From: Sue Howell
Sent: 06 July 2015 16:28
To: Planning.Responses
Cc: Juan Baeza
Subject: RE: Planning Consultation on LU/197/15/DOC

Comment from Greenspace

APPLICATION LU/197/15/DOC
NO:

Application for approval of matters reserved by conditions imposed under LU/385/14/PL relating to condition No's 3, 8, 10, 11 & 12 - Solar Farm Materials, Landscaping Scheme, Traffic Management plan & SHE Quality plan.

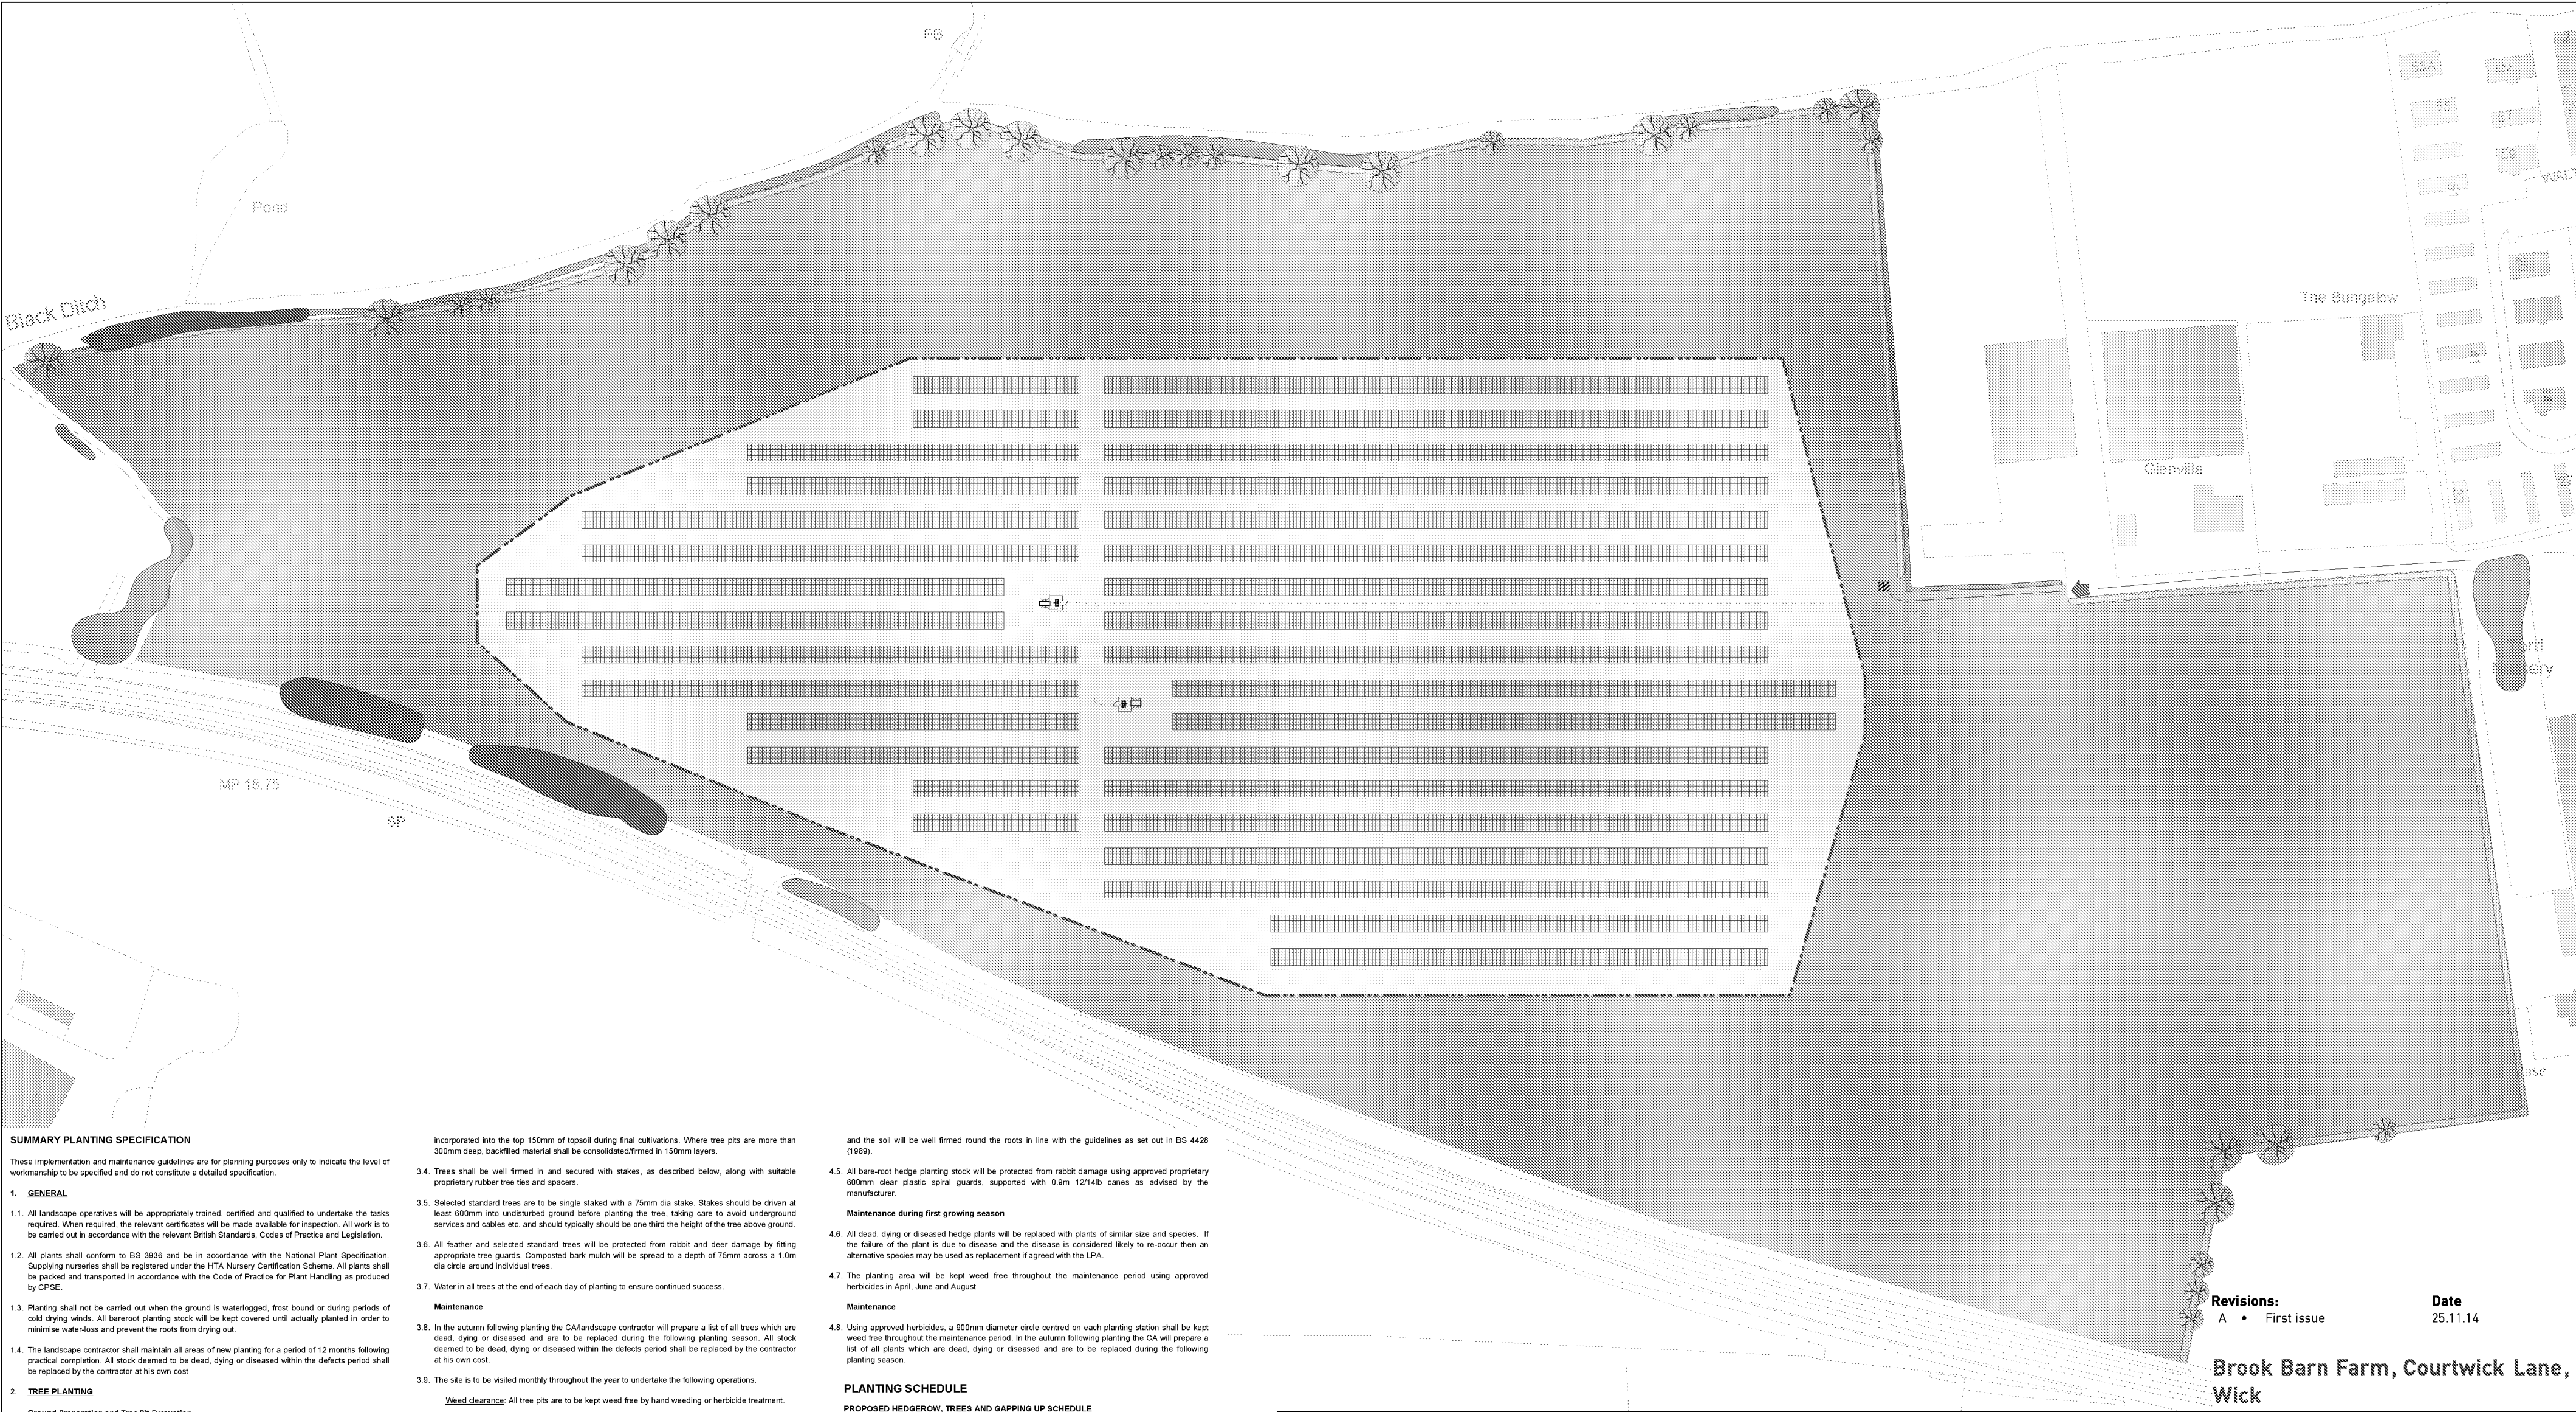
The landscape plan BNL.0638-06-A Revision A submitted under application LU/197/15/DOC does not adequately detail proposed planting. The detail needs to be in plan form and needs to show actual quantities and locations for proposed planting. Indicative areas of proposed planting is not sufficient to adequately show where planting is to be located. The drawing schedule presently indicates proposed sizes only, this needs to be incorporated into a schedule with the quantities so that a clear picture of the proposals can be seen.

We would require that the above information is submitted and agreed and therefore **we would not at this stage recommend the discharge of Condition 8 on this application**
